# KITTITAS COUNTY

### MEMORANDUM

**TO:** All Staff  
**FROM:** Public Works Plan Review Team  
**DATE:** September 1<sup>st</sup>, 2023  
**SUBJECT:** Public Works Comments: BL-23-00015 Hawkmeadow Ranch LLC

PRELIMINARY BOUNDARY LINE ADJUSTMENT

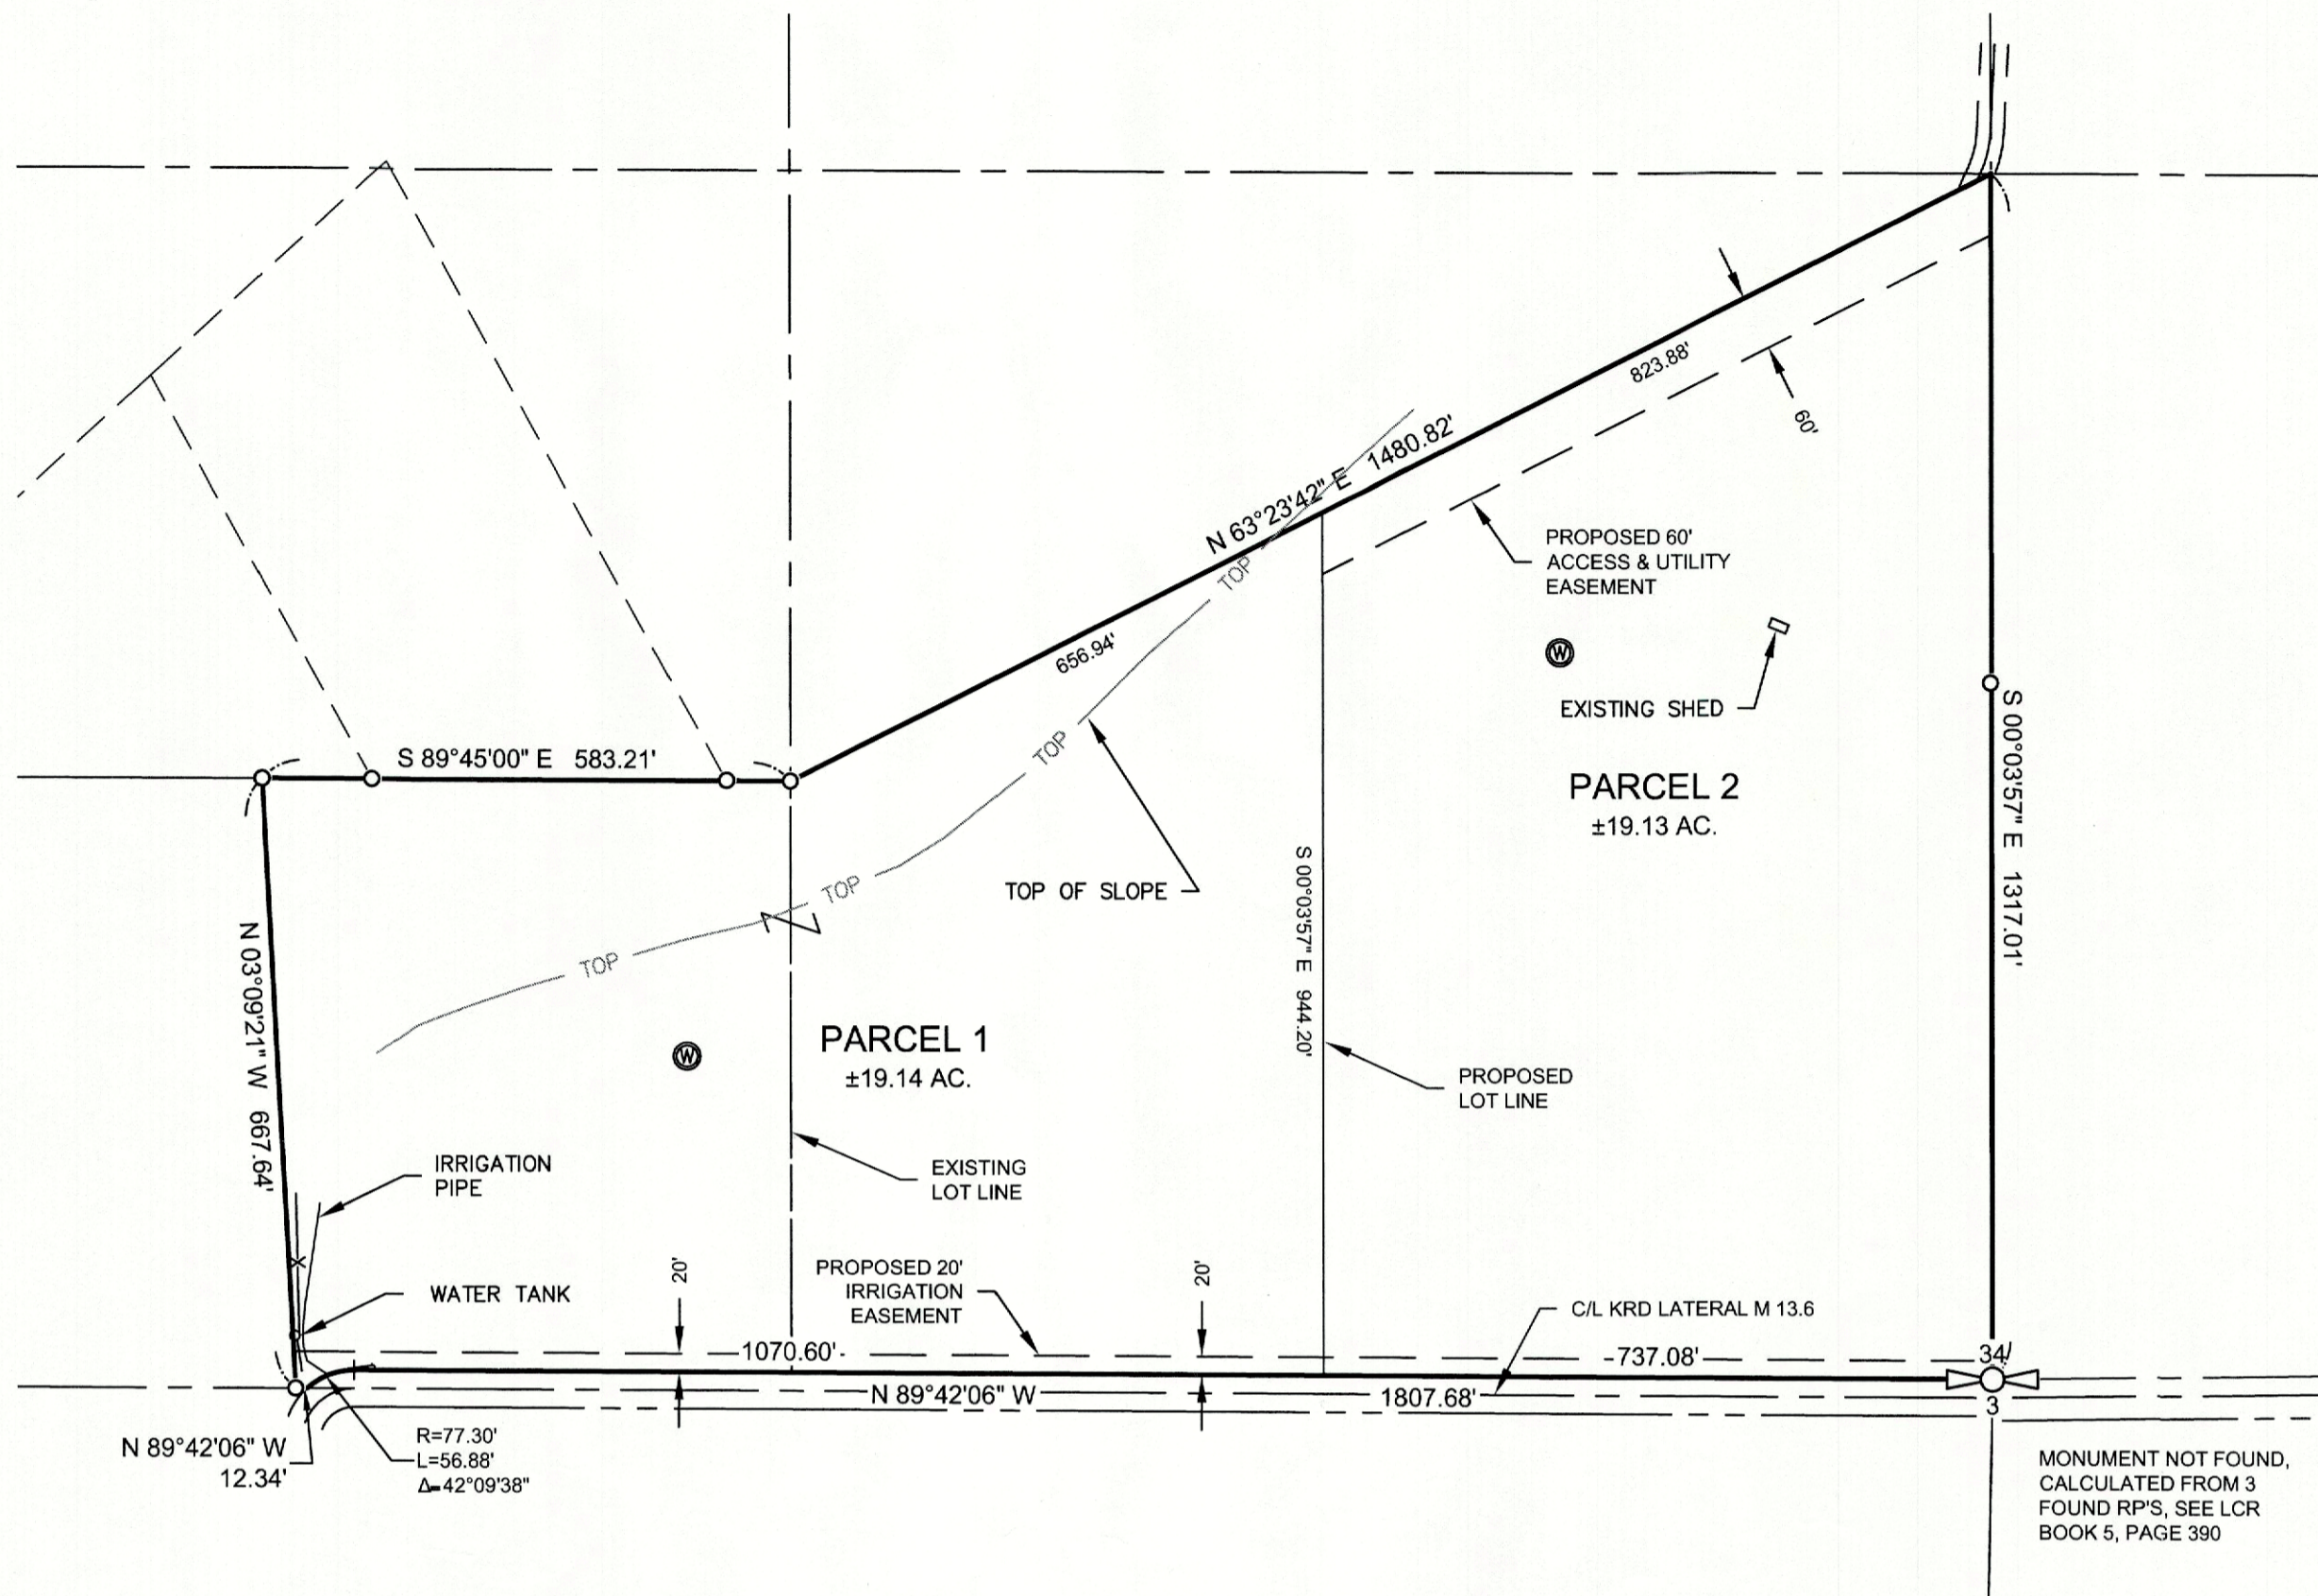
<b>ACCESS</b>	<ol style="list-style-type: none"> <li>1. An approved access permit shall be required from the Kittitas County Department of Public Works prior to creating any new driveway access or altering an existing access.</li> <li>2. Maintenance of driveway approaches shall be the responsibility of the owner whose property they serve. The County will not maintain accesses.</li> <li>3. Any further subdivision or lots to be served by proposed access may result in further access requirements. See Kittitas County Road Standards.</li> <li>4. In addition to the above-mentioned conditions, all applicable Kittitas County Road Standards apply to this proposal. Access is not guaranteed to any existing or created parcel on this application.</li> </ol>
<b>ENGINEERING</b>	No comments (KAH)
<b>SURVEY</b>	<p>Site plan is suitable for application. BLA survey map will be reviewed at final. (JT)</p> <p>UPDATE 11/13/2023</p> <ol style="list-style-type: none"> <li>1. Please add a label for Dunnigan Ave. As this just a reference to access to public right of way, there is no need to include R/W width, surfacing or ownership information.</li> <li>2. Please change the new legal description for Parcel 1 from to "...South Half of the Southwest quarter <del>of the southwest quarter</del> of Section 34...."</li> </ol> <p>Of note, not required</p> <ol style="list-style-type: none"> <li>1. The dimension details at the Southwest corner of Parcel 1 would benefit from a detail window or by moving the dimension labels around to make it clearer.</li> <li>2. Lot closures were not reviewed as part of this application. Given the simple nature of the BLA, no lot closures are necessary.</li> </ol>

<p>UPDATE 12/11/2023</p> <p>All prior survey comments have been addressed. (JT)</p>
<b>TRANSPORTATION CONCURRENCY</b>	<p>1. A transportation impact analysis (TIA) shall be required for all development that will generate more than nine (9) peak hour vehicle trips. Please provide estimated traffic generation for peak hours to determine if a TIA will be required. (KCC 12.10.040(c))</p> <p>(KAH)</p>
<b>FLOOD</b>	No Comments (AT).
<b>WATER MITIGATION/ METERING</b>	No Comments (AT).
